Application No: AB/50/21/L
Site Address: Old Bank House 1 High Street Arundel BN18 9AD
Description of works: Listed building consent for the replacement of all windows with new timber double glazed sliding box sash windows and the proposed rendering of the South Elevation (front) and the West Elevation (side) with render painted white.

Thank you for your internet representation made on 16th May 2021 which has been recorded as an objection with the comments as follows:

Project:-			
Old Bank House 1 High Street Arundel West Sussex			
Title:-			
Proposed Floor Plans & Elevations			
Client:-			
Moor Construction Ltd			
Scale:-			
1:50, 1:100 (@A1)			
Drawn By:-	PJD	Checked By:-	
Date:-	10/04/21	Date:-	
Job.No:-	200042	Drg.No:-	46

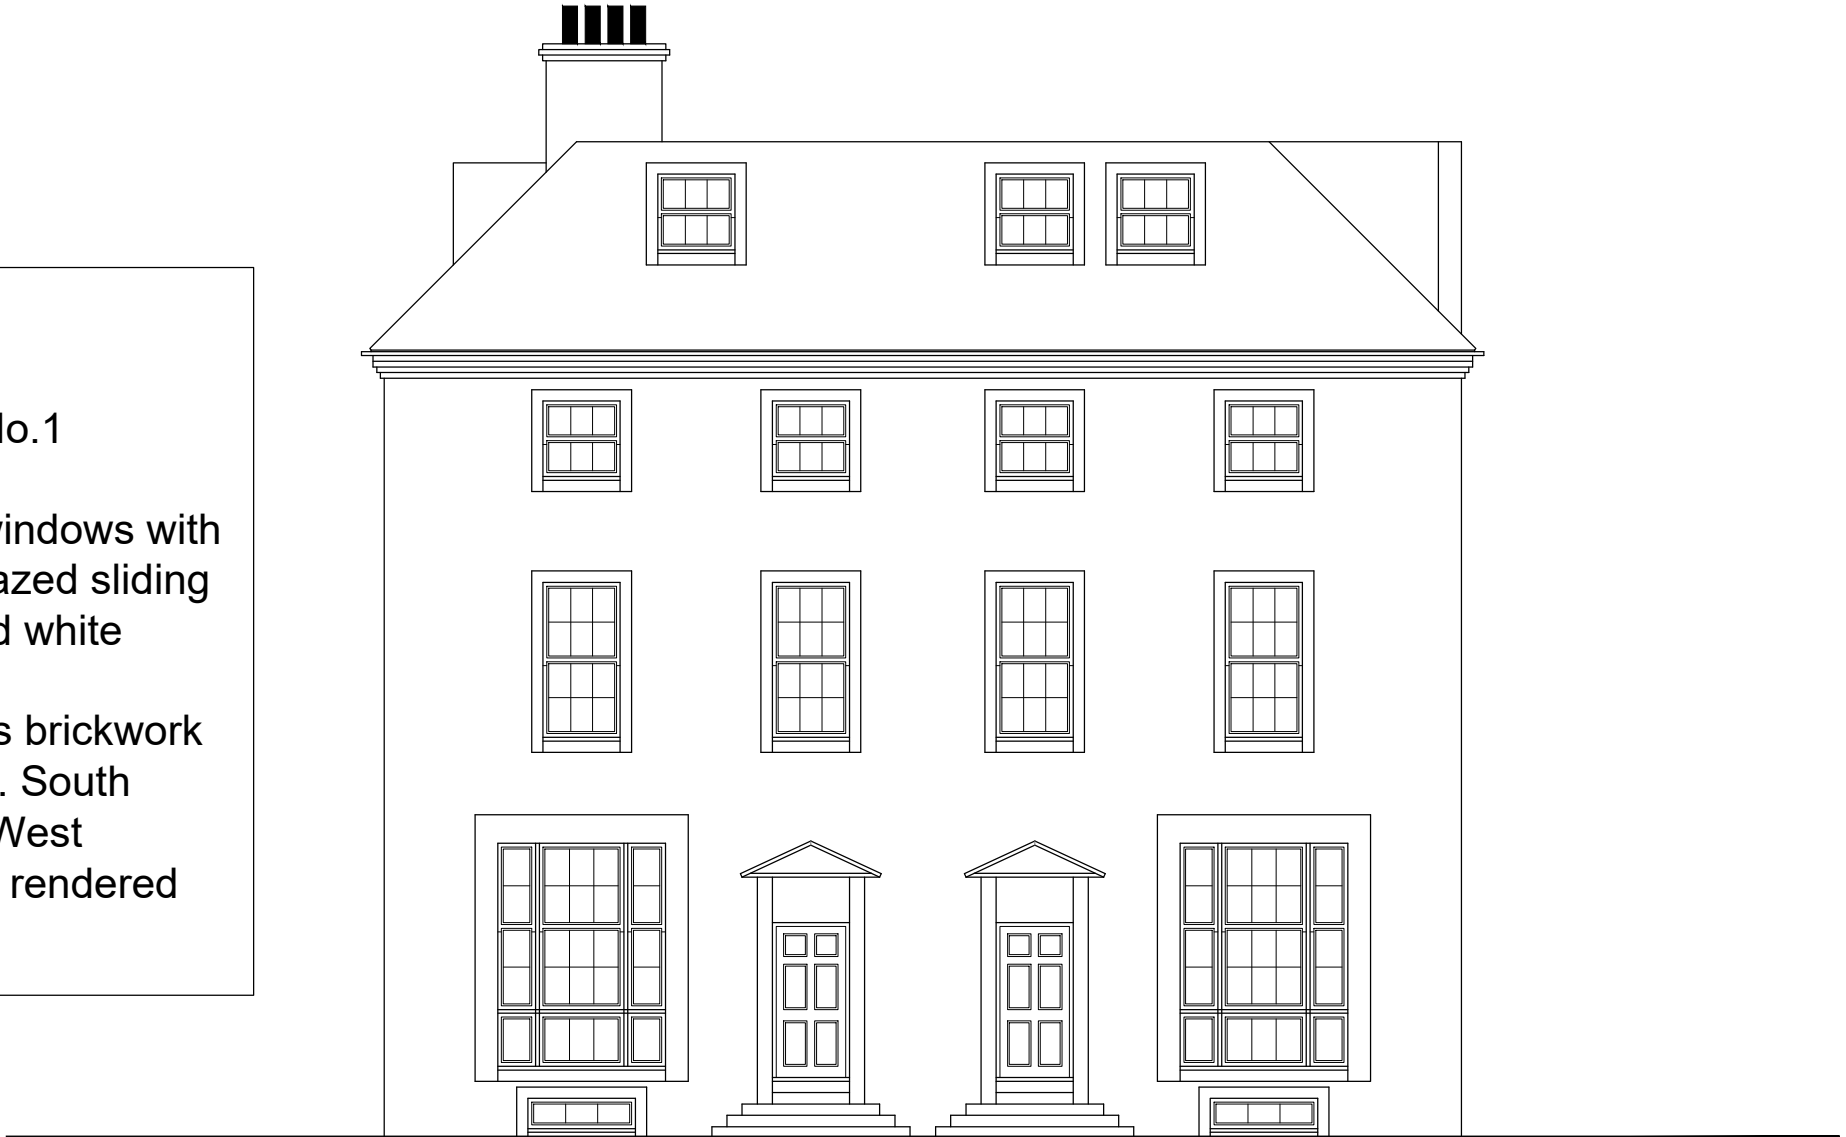
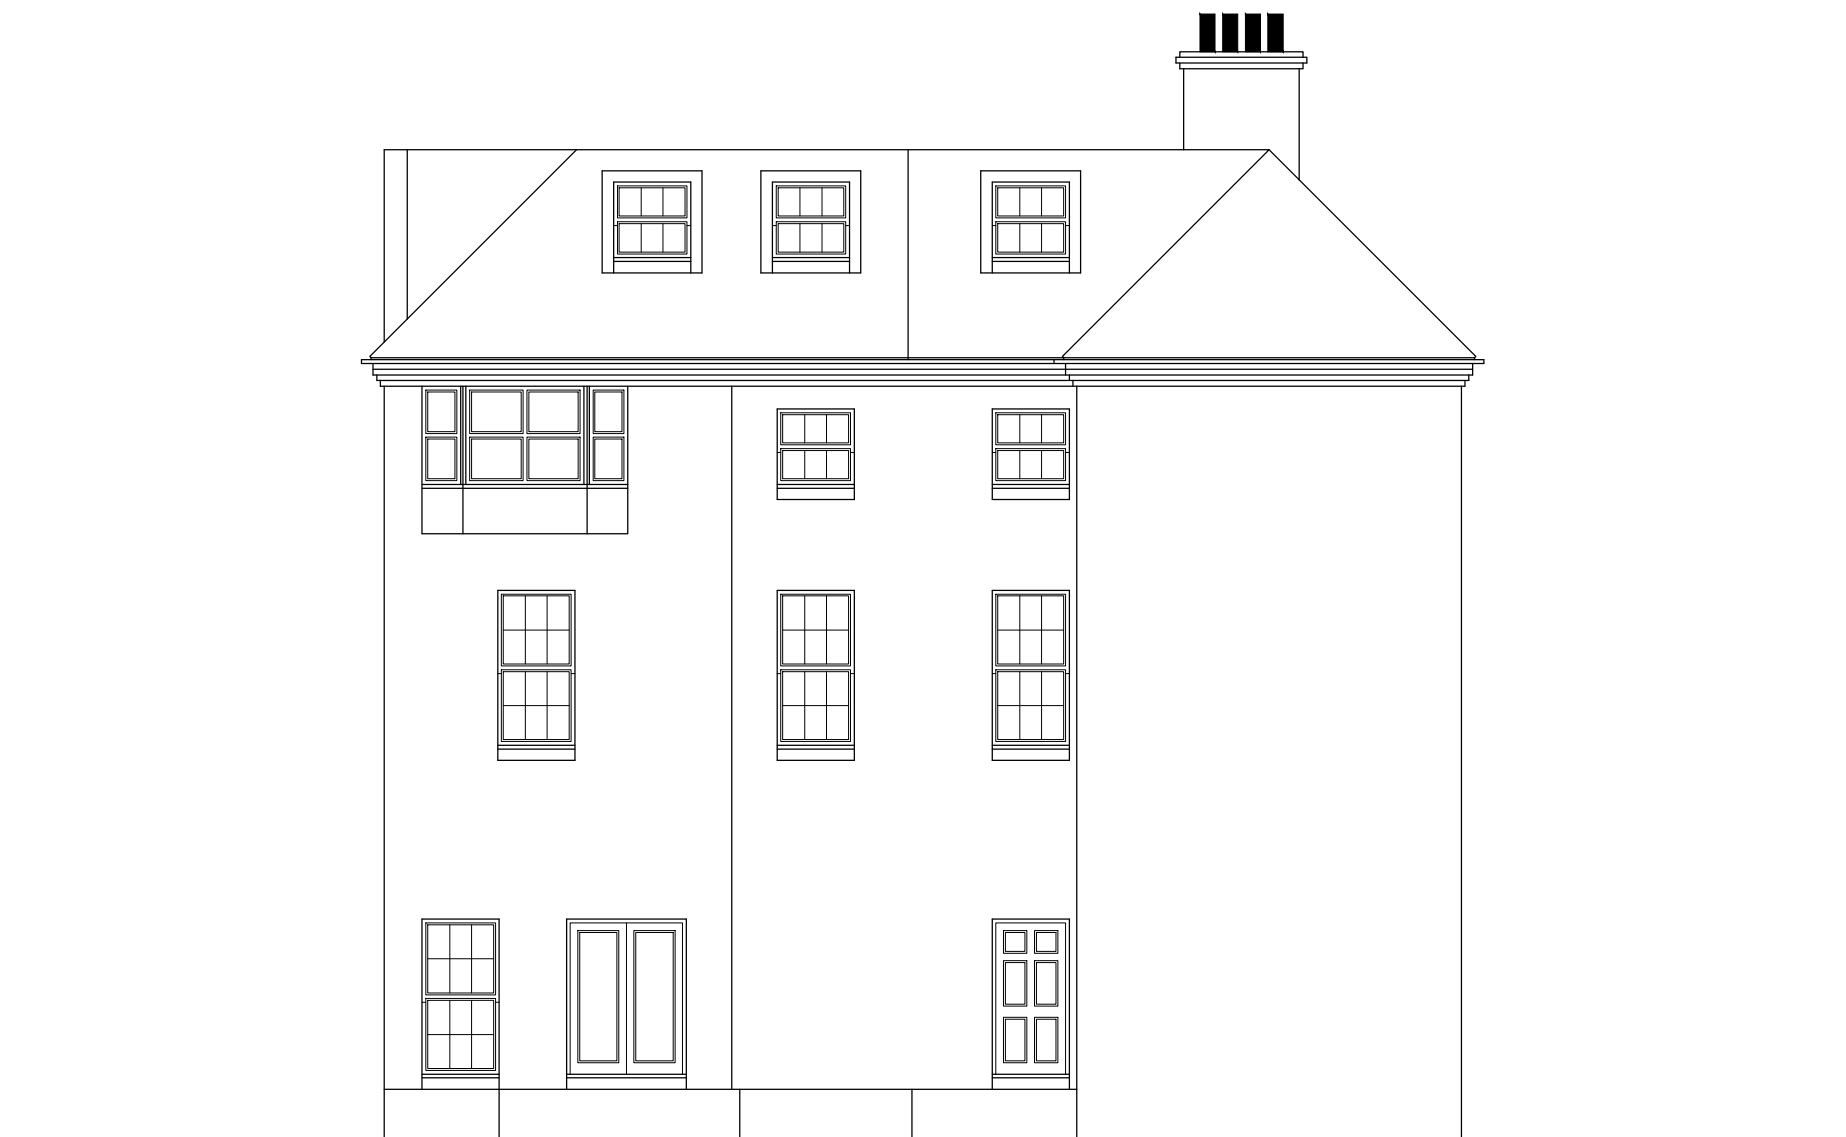
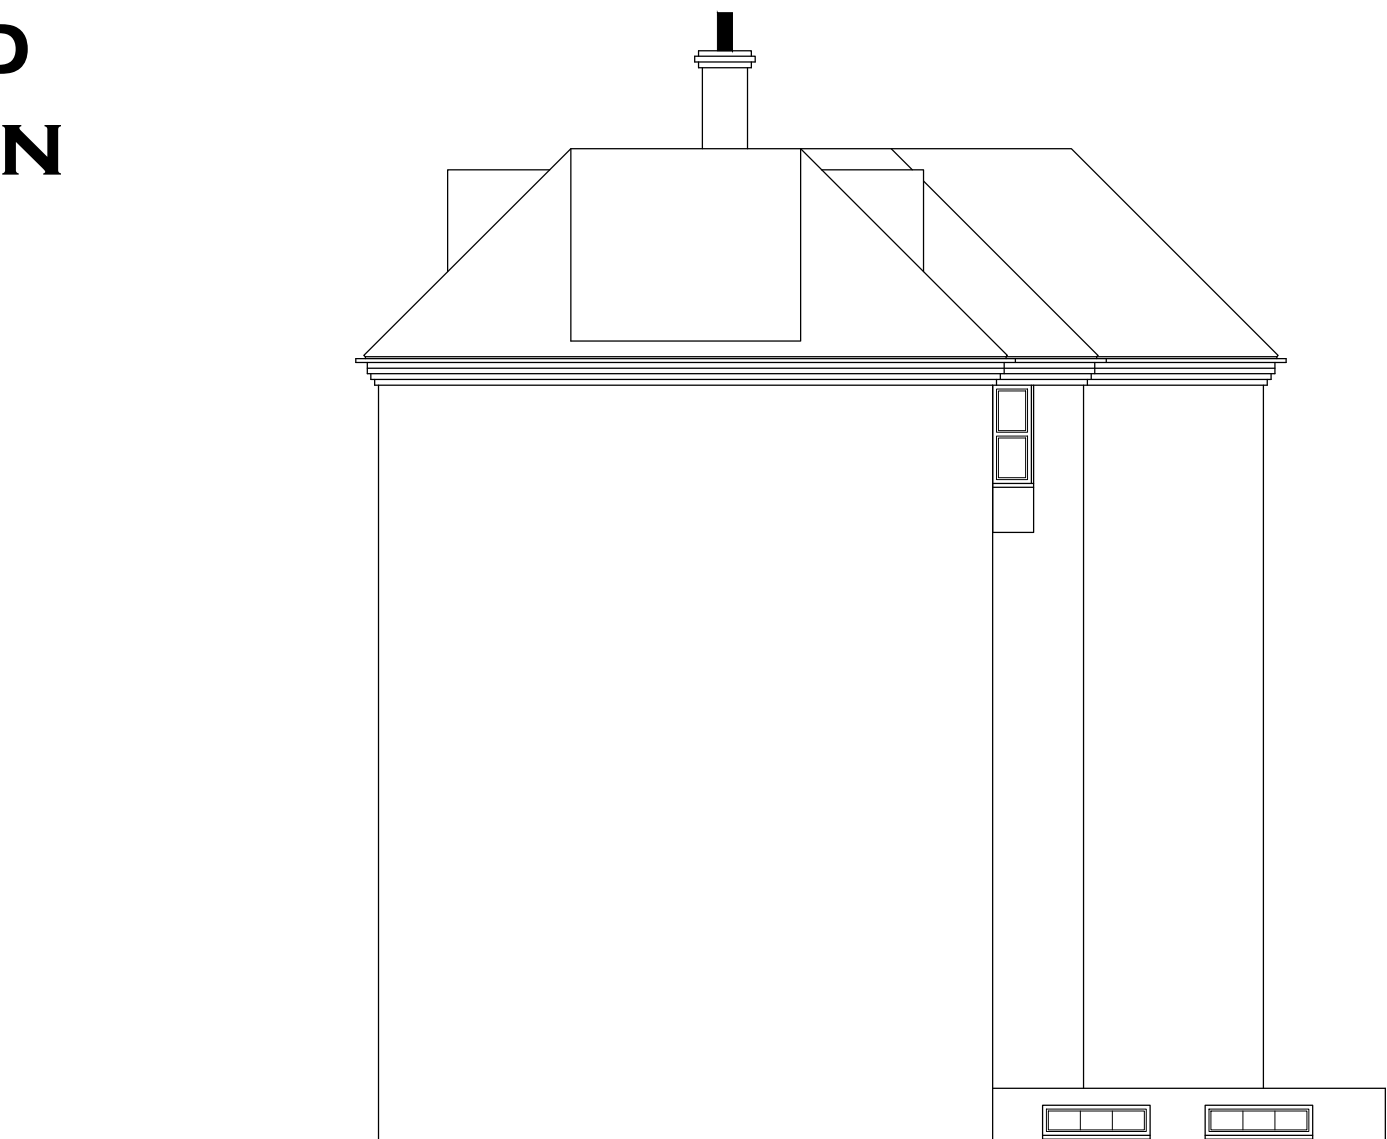
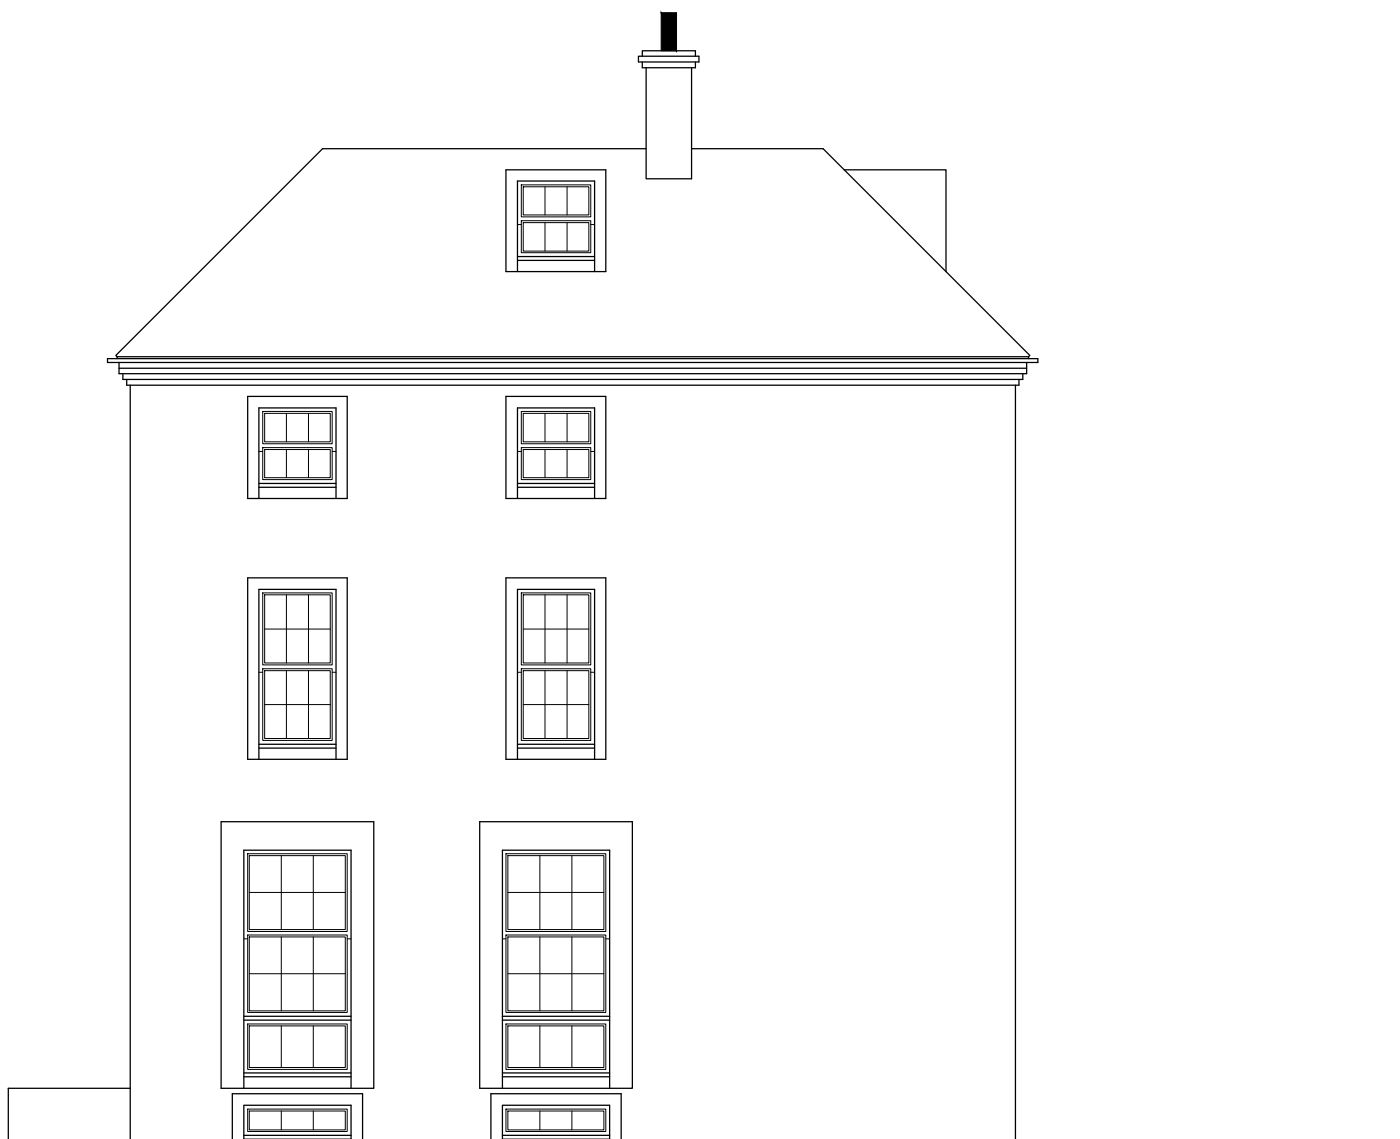
The Committee objected to the application on the grounds of affecting the street scene and that the windows should be in the original style using secondary glazing rather than using replacement double glazing.
